From: Amanda Scholes on behalf of Planning.Responses
Sent: 10 March 2017 09:05
To: Planning Scanning
Subject: FW: AL/107/16/RES - public open space plan

From: Sue Howell
Sent: 09 March 2017 15:34
To: Lucy Harding
Subject: RE: AL/107/16/RES - public open space plan

drawing: Landscape Proposals
date: May 2016
scale: 1:200/@A1
drawing no: BDWS20440 11B sheet2
drawn: DC checked: AE

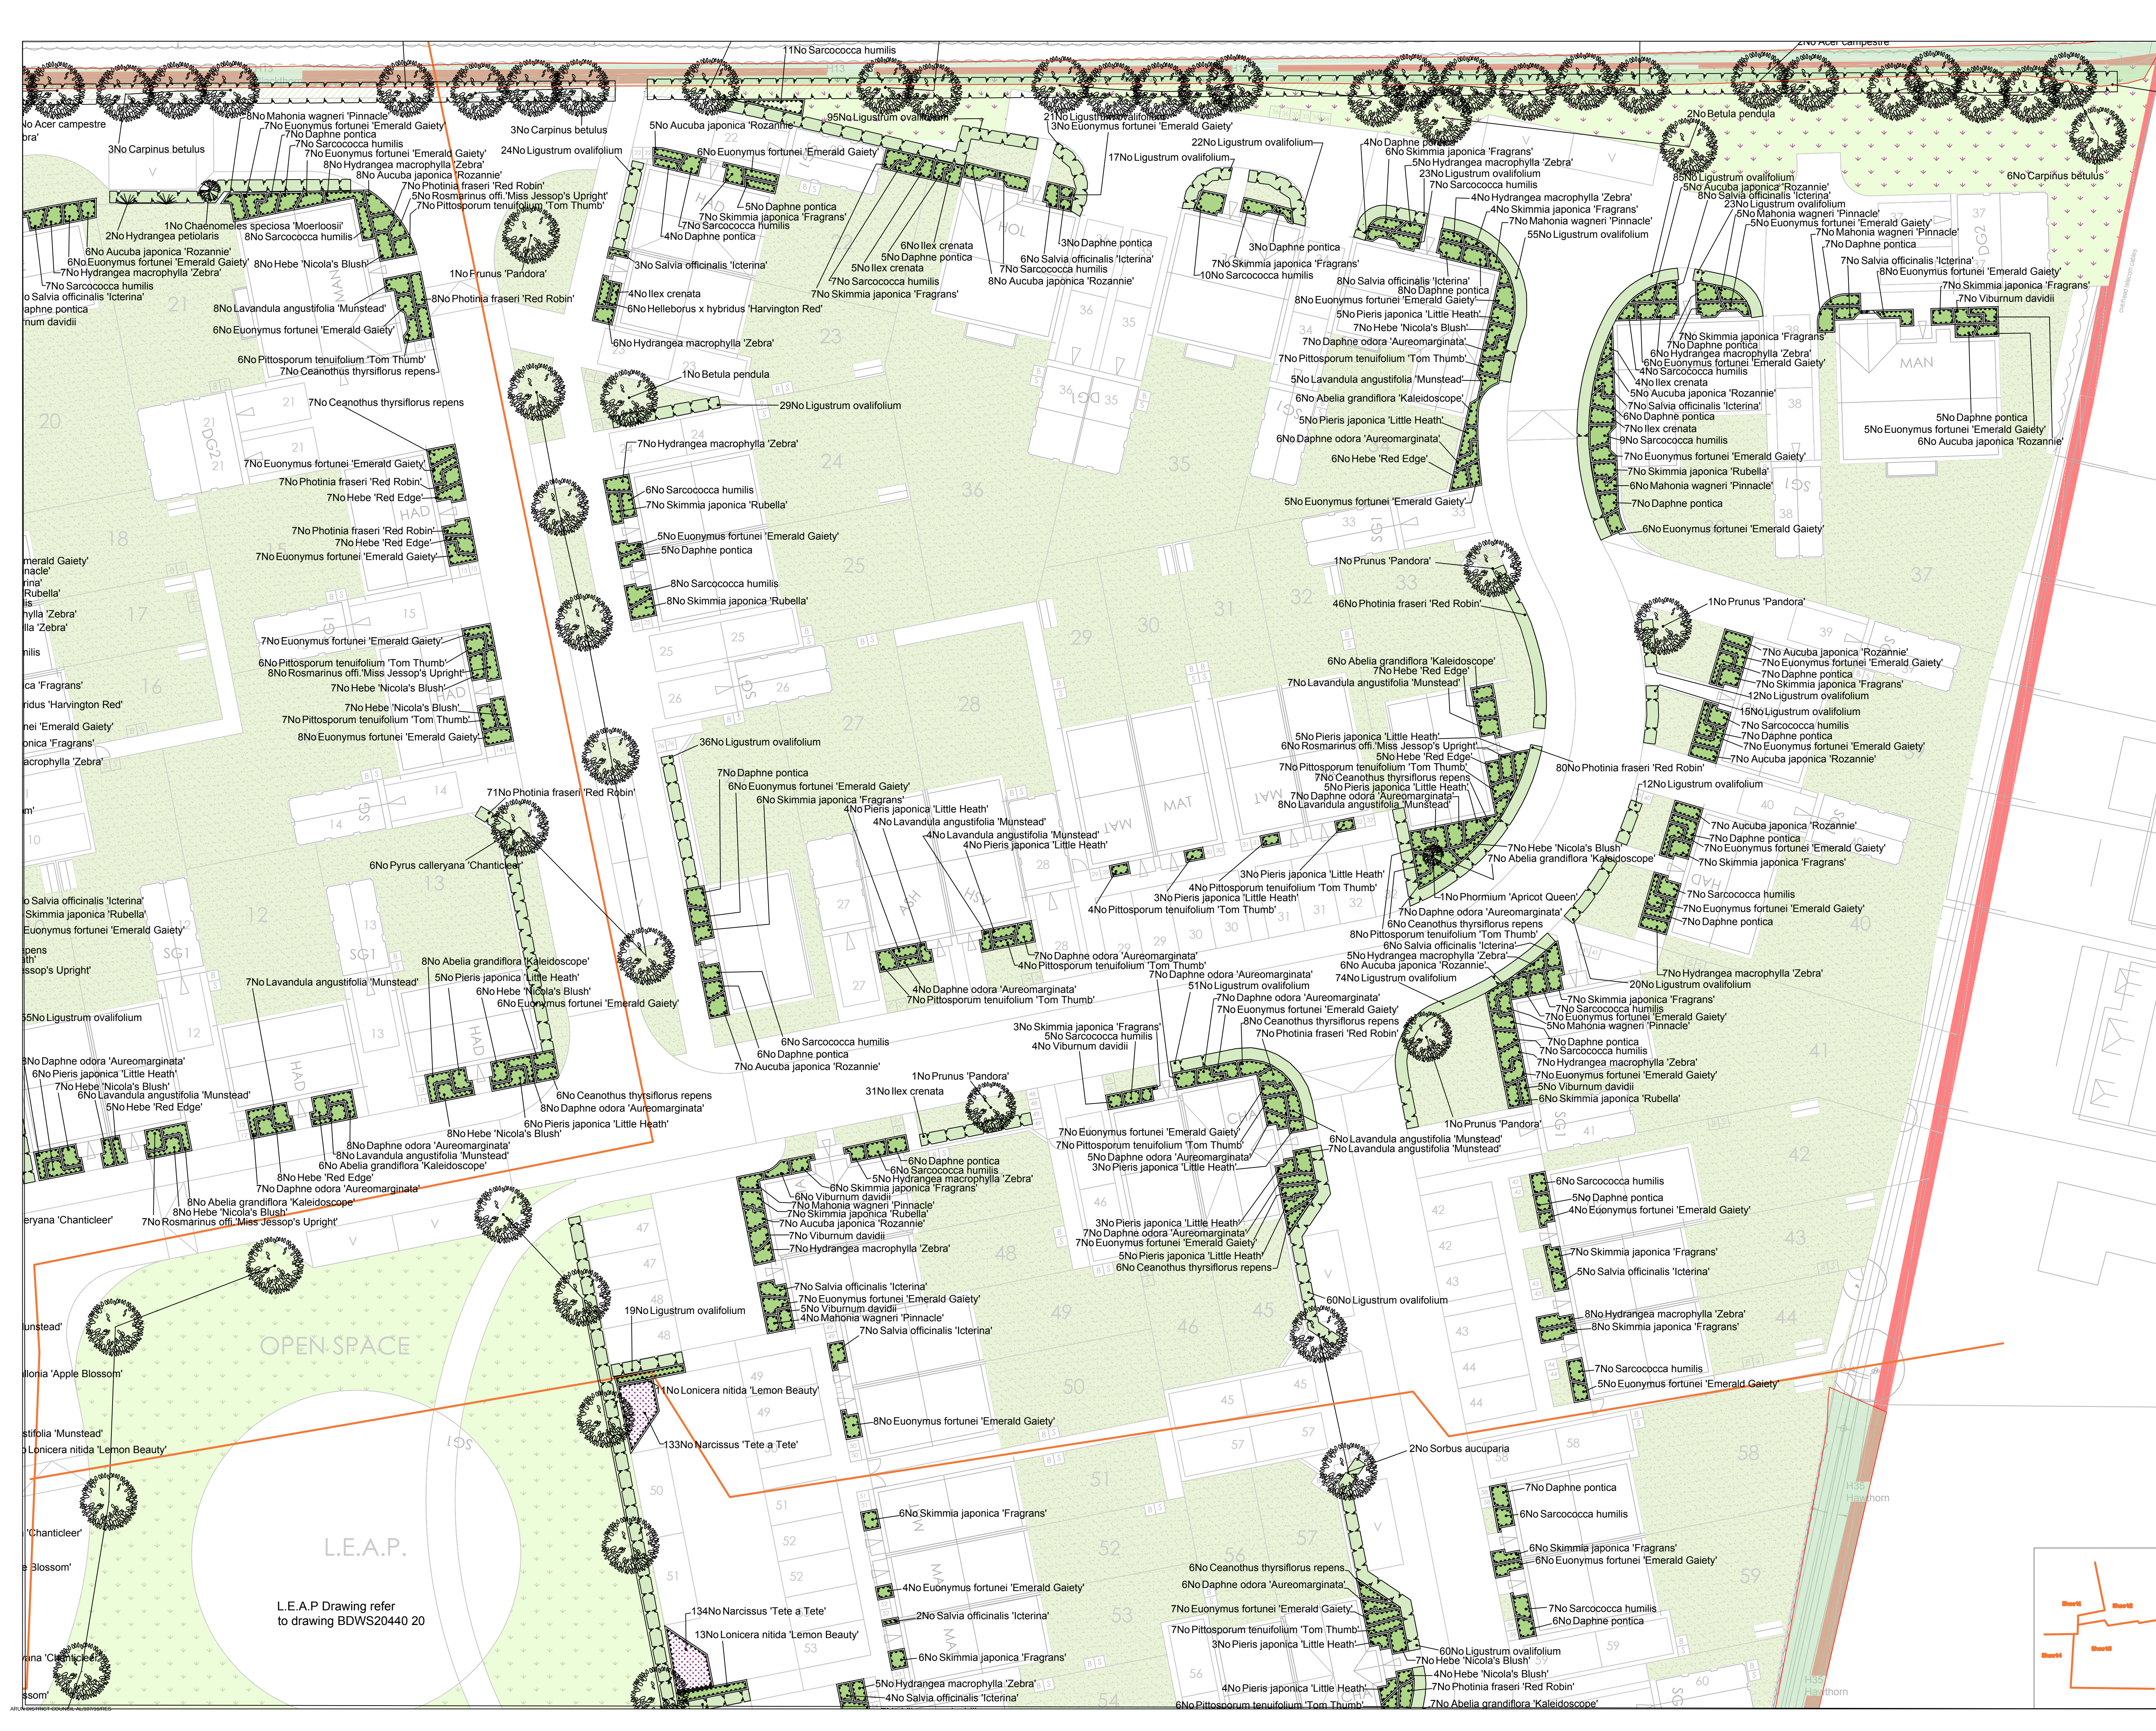
Thanks for various emails on this, I have now had a look at the drawing and they have confirmed the amount of open space being provided, which does tie in with our existing SPG guideline so would be fine. We would struggle to insist on the updated FIT standards whilst our existing SPG stands.

The centrally located LEAP is fine, but I can't see any mention now of LAP? Can they confirm where this will be and that they have in fact provided the require play provision otherwise s106 monies would need to be sought for offsite play provision?
